**Addendum No. 2**

RE: Contract ID: C201744

Wake County (U-3344A)

SR-3015 (Airport Blvd.) From NC-54

UTILITIES BY OTHERS

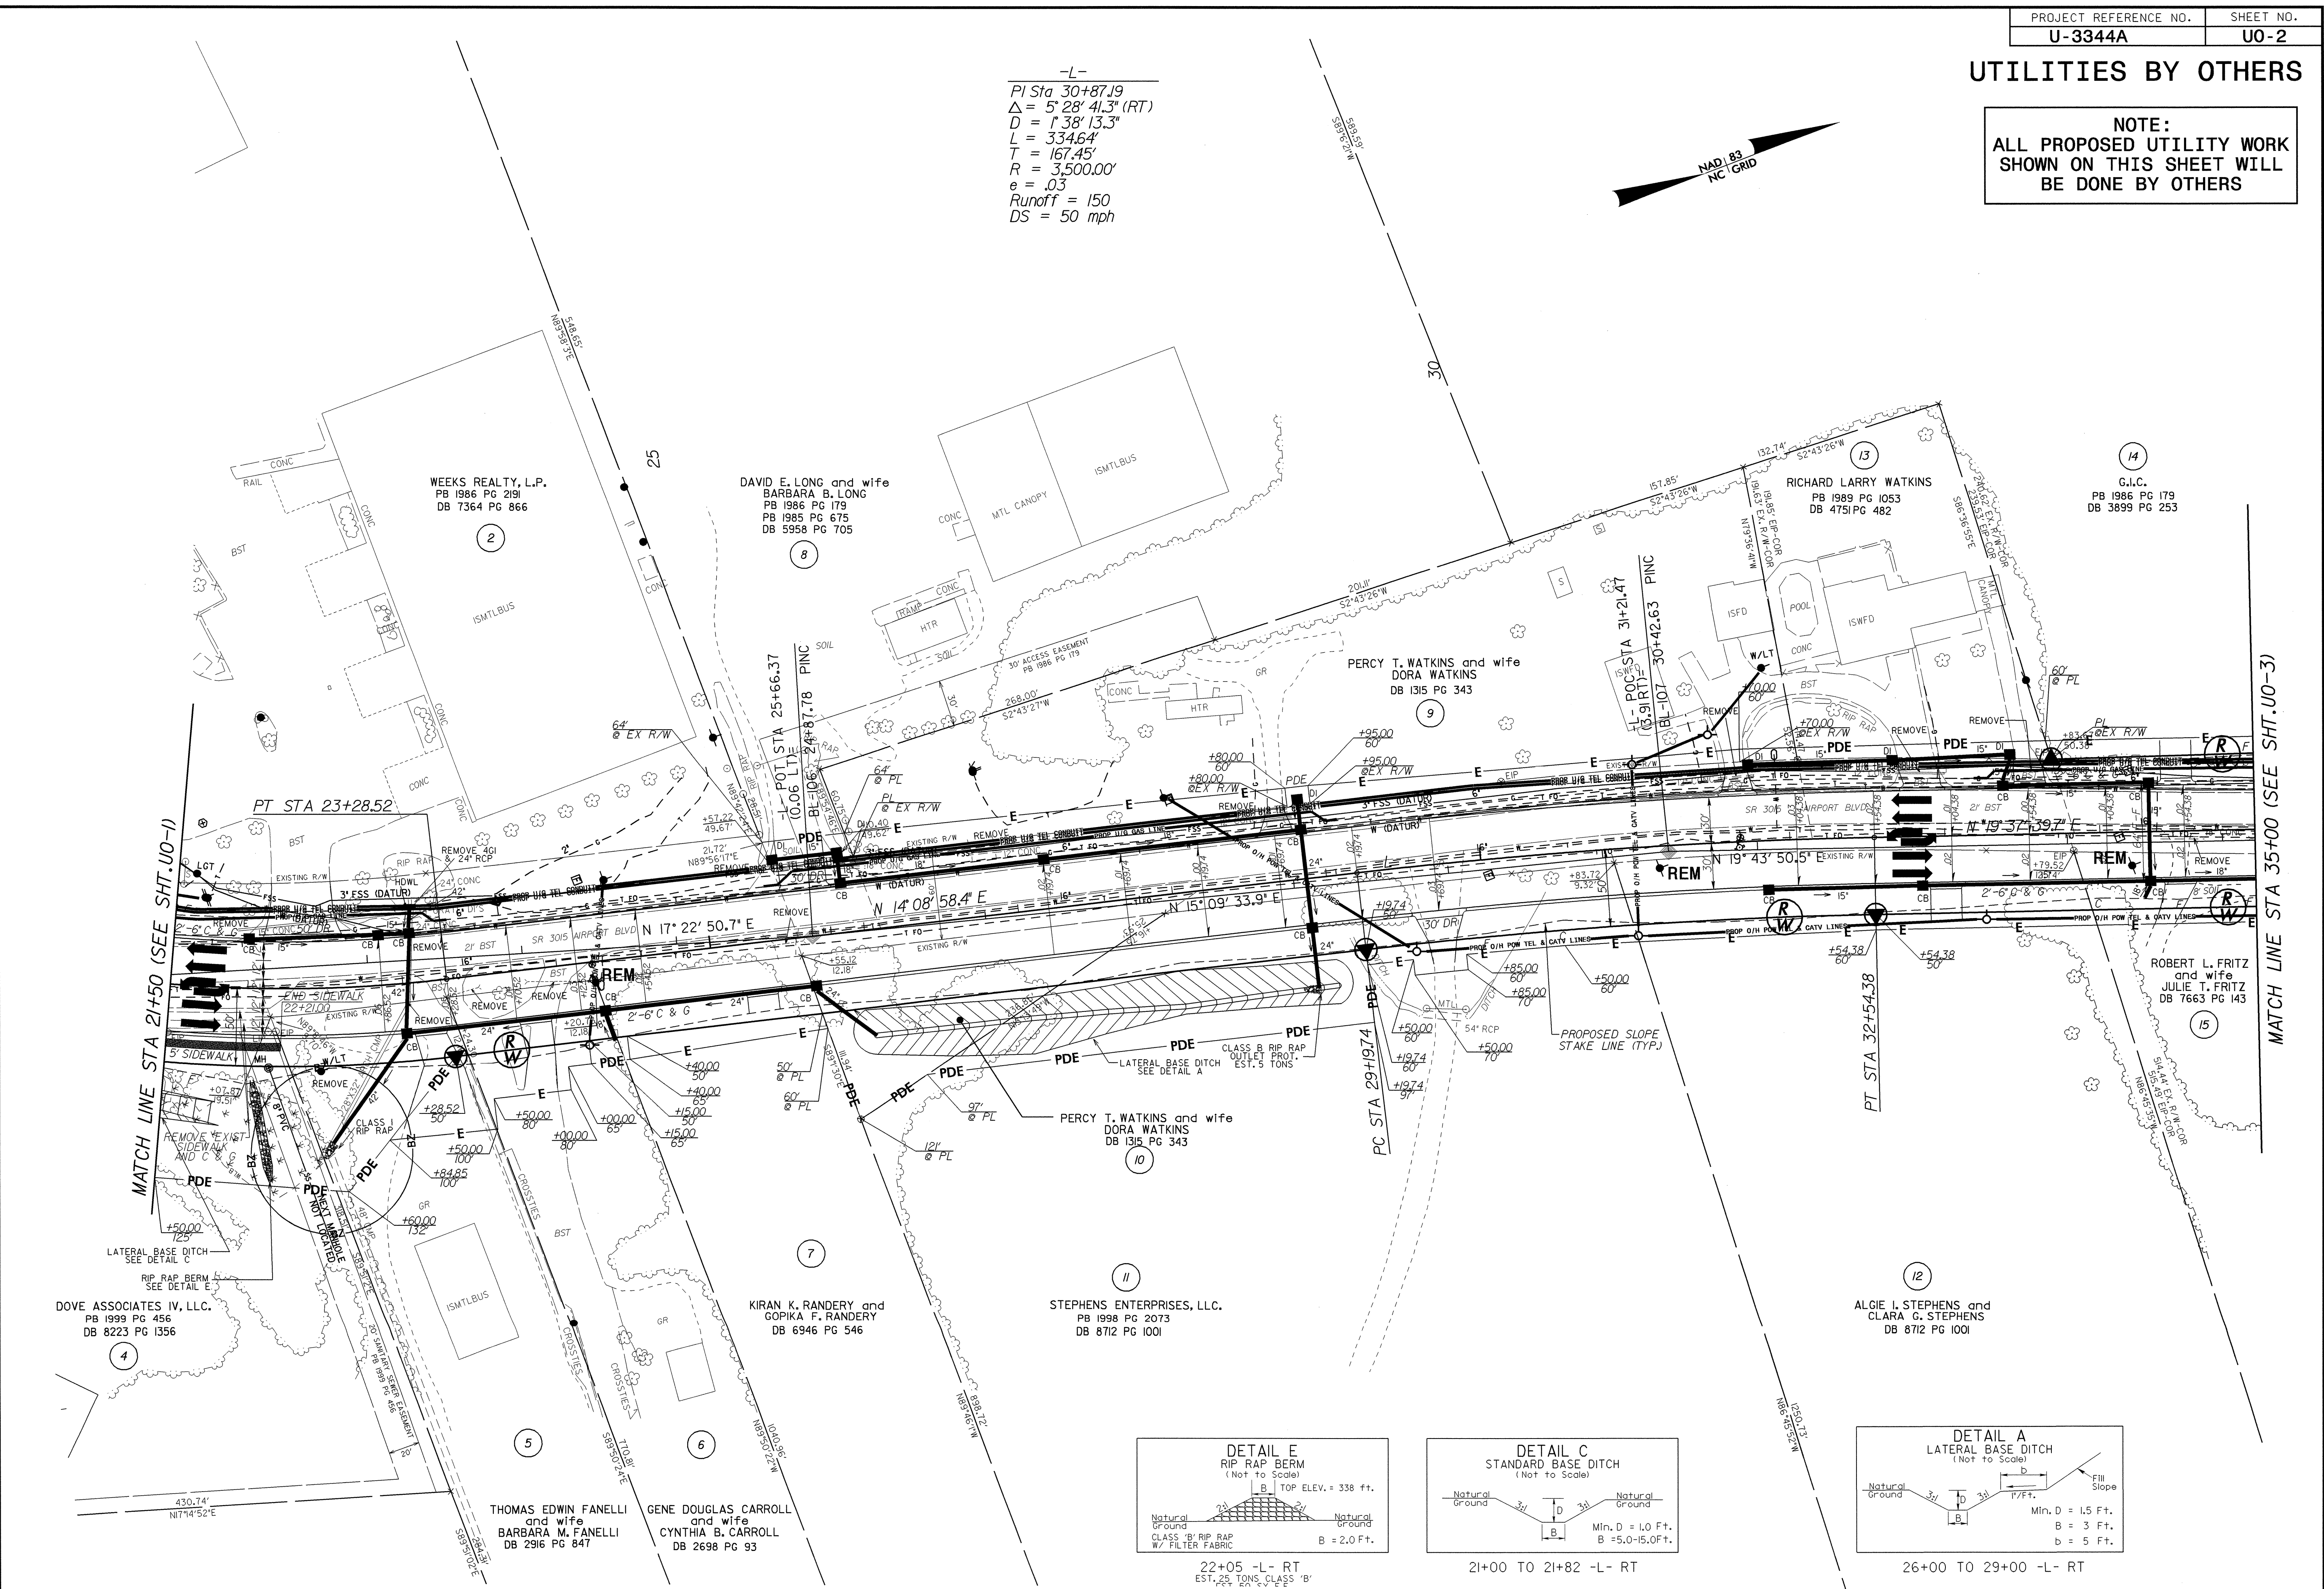
On Page Nos. 54 and 55, the project special provision entitled "Utilities By Others" has been revised. Please void Page Nos. 54 and 55 in your proposal and staple the revised Page Nos. 54, 54-A and 55 thereto.

to installation of drainage structures right of line -L- from Station 13+00 to Station 20+00 and then allow Bell South two weeks to complete any adjustments necessary to correct any conflicts with the proposed drainage. The removal of the existing Controlled Environmental Vault left of line -L- at Station 14+70 will be completed by Bell South by May 15, 2007.

The contractor shall give Public Service NC a minimum of two weeks notice prior to beginning construction of the proposed reinforced concrete box culvert at Station 37+45 -L- and then allow PSNC one week to cut and cap the existing gas line on each side of the proposed culvert construction site. After completion of the proposed RCBC, the contractor shall give PSNC a minimum of two weeks notice and then allow PSNC one week to reconnect and install the new gas line section over the proposed RCBC prior to the contractor placing backfill over the proposed RCBC in the location of the new section of gas line.

NOTE: Contractor shall give ITC/Deltacom one week notice prior to installation of drainage structures left of line -L- from Station 25+00 to Station 35+00 and then allow ITC/Deltacom one week to install a new conduit system in joint use with the proposed drainage.

Contractor shall give ITC/Deltacom one week notice prior to completing rough grading right of line -L- from Station 39+00 to Station 42+00 and then allow ITC/Deltacom one week to install new conduit system by directional bore after completion of rough grading.
